Response to Planning application from Hertfordshire County Council (T and CP GDP Order 2015)

District ref: 6/2020/1463/FULL
HCC ref: WH/2479/2020
HCC received: 3 July 2020
Area manager: Alan Story
Case officer: Paul Marshall

1 MAYNARD PLACE CUFFLEY POTTERS BAR EN6 4JA

Erection of a one storey roof extension to create no 6 flats including 3 x 1 bed and 2 x 2 bed flats, associated parking and cycle and refuse provision.

DRAWING NUMBER:	REV:	ISSUED BY:
1254.01.001		CF

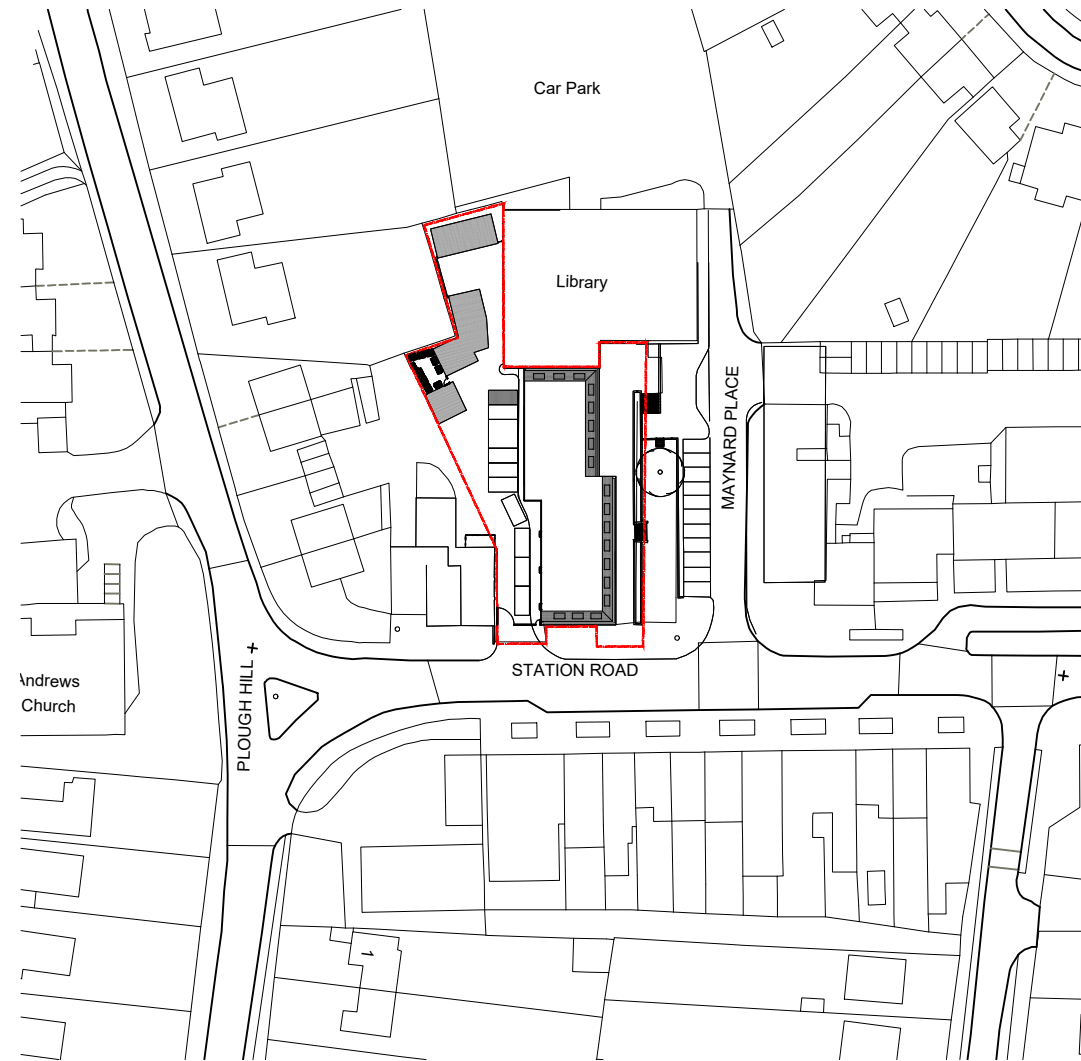
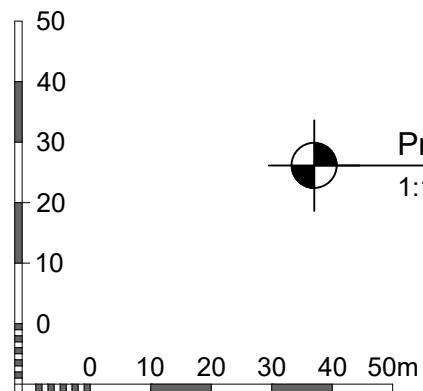
Drawing 1254.01.001 demonstrates an unsatisfactory form of car park layout. My first issue is with the site visit in relation to parking. I assume from the Transport note the visit was undertaken in June of this year? Having visited the site on the 21st July and speaking to business owners the parking conditions are not typical during this Covid period. My impression is this area does not provide the required number of parking bays and parking is a very real problem for residents and business owners.

The second issue I have is that not all of the garages are owned by residents. Indeed, one of the garages is owned or rented by the Parish Council for the storage of Christmas lights. A number of the garages are used for local businesses for storage. This may not be an issue if the applicant has arranged to purchase the garages separately? However, if this is the case then there is a shortfall in the parking requirements.

Looking at parking bays 1 to 4 these do not comply with Manual for Streets 8.3.48 which states 'For parking parallel to the street, each vehicle will typically need an area of about 2m wide and 6m long'. Parking bays 5-7 do not have the required 6m manoeuvrability as the boundary line restricts this. Any possible future development up to the boundary line would leave a minimum of between 3 and 5m manoeuvrability.
